Our Ref: EN010012

#### **Application by NNB Generation Company (SZC) Limited for an Order Granting Development Consent for The Sizewell C Project.**

#### **Procedural decision during Pre-examination stage**

DRAWING TITLE:
 MAIN DEVELOPMENT SITE AND RAIL
 RIGHTS OF WAY PLANS - SHEET 3 OF 28

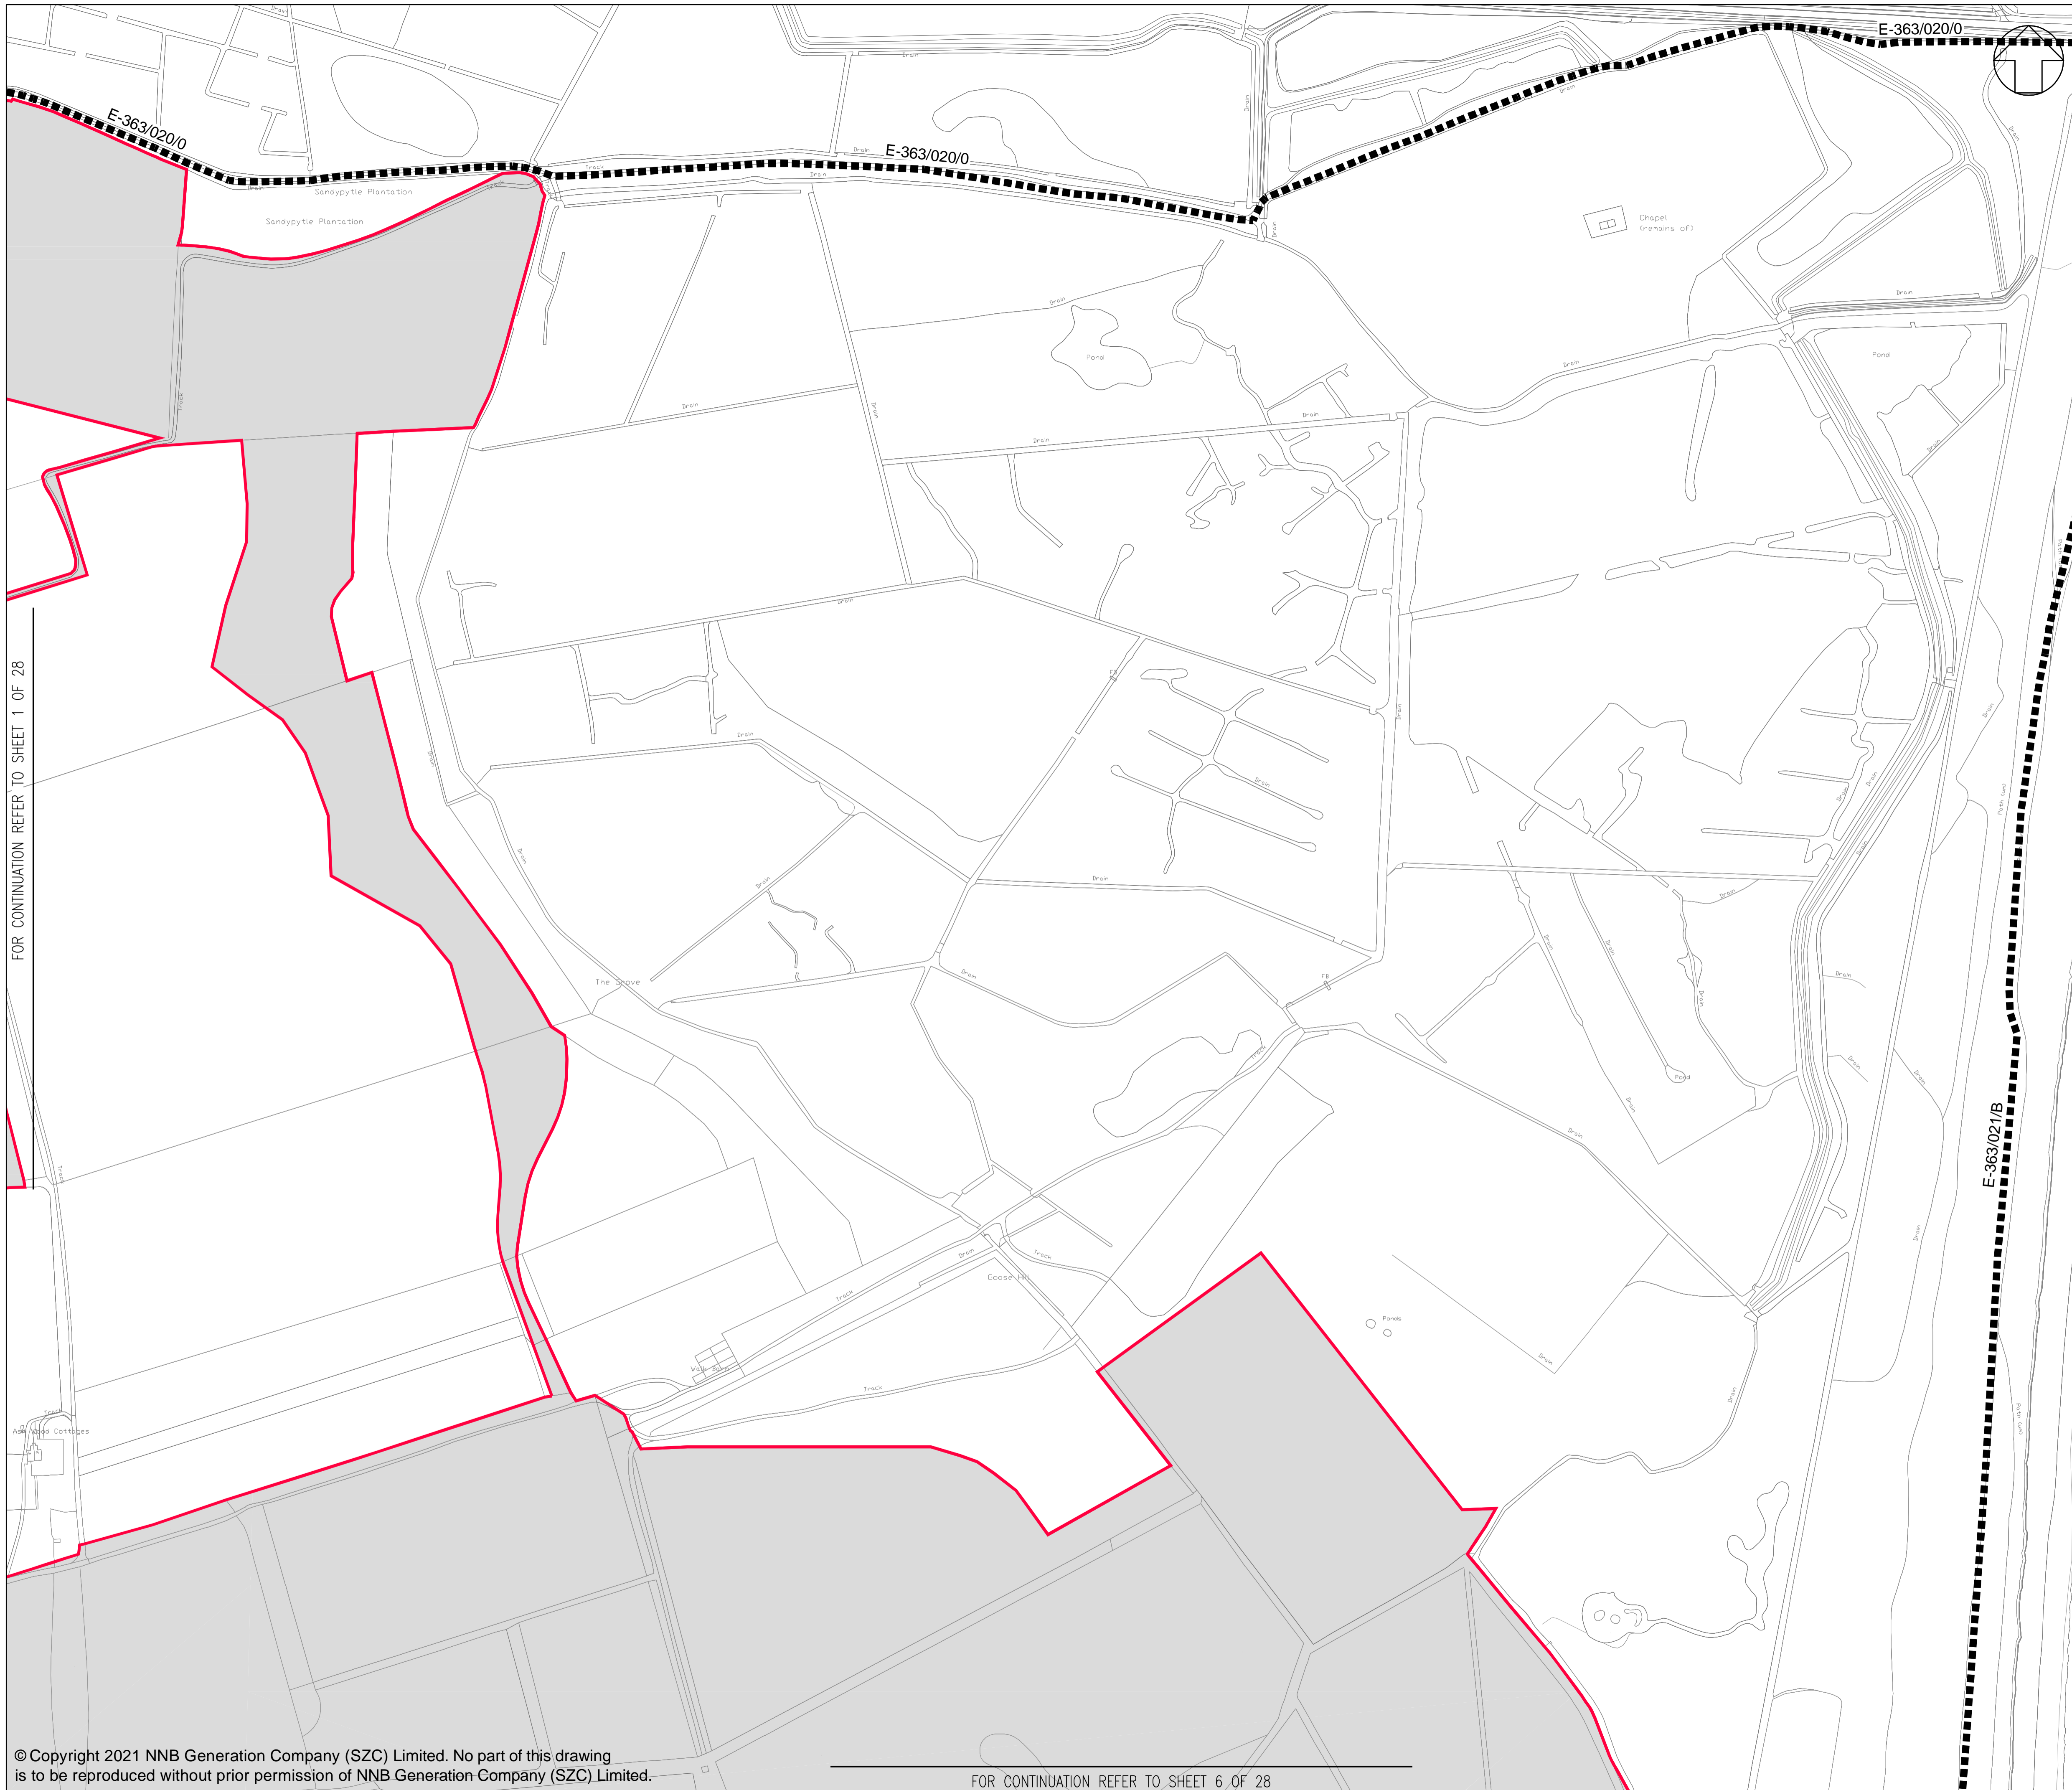
- i. RoW Plan Sheet 2 of 27. Main development site and rail – There is no road labelled Eastbridge Road on any plans.
- ii. RoW Plan Sheet 17 of 27. Two village bypass – Tinker Brook and access to Parkgate Farm – New highway points between PCH11/1, PCH11/12 and PCH11/2. PCH11/12 is not on any plans.
- iii. RoW Plan Sheet 17 of 27. Two village bypass – Access to Parkgate Farm – Private means of access between points PSA11/1 and PSA11/2. There is no PSA11/1 or PSA11/2 on the plans.
- iv. RoW Plan Sheet 24 of 27. Yoxford roundabout – Highway between points PSH14/1 and PCH14/2. PCH14/2 should be PSH14/2.
- v. RoW Plan Sheet 24 of 27. Yoxford roundabout – B1122 Yoxford Road – Highway between points PSH14/5 and PSH14/6. The reference in Schedule 10 should be to Middleton Road not Yoxford Road.
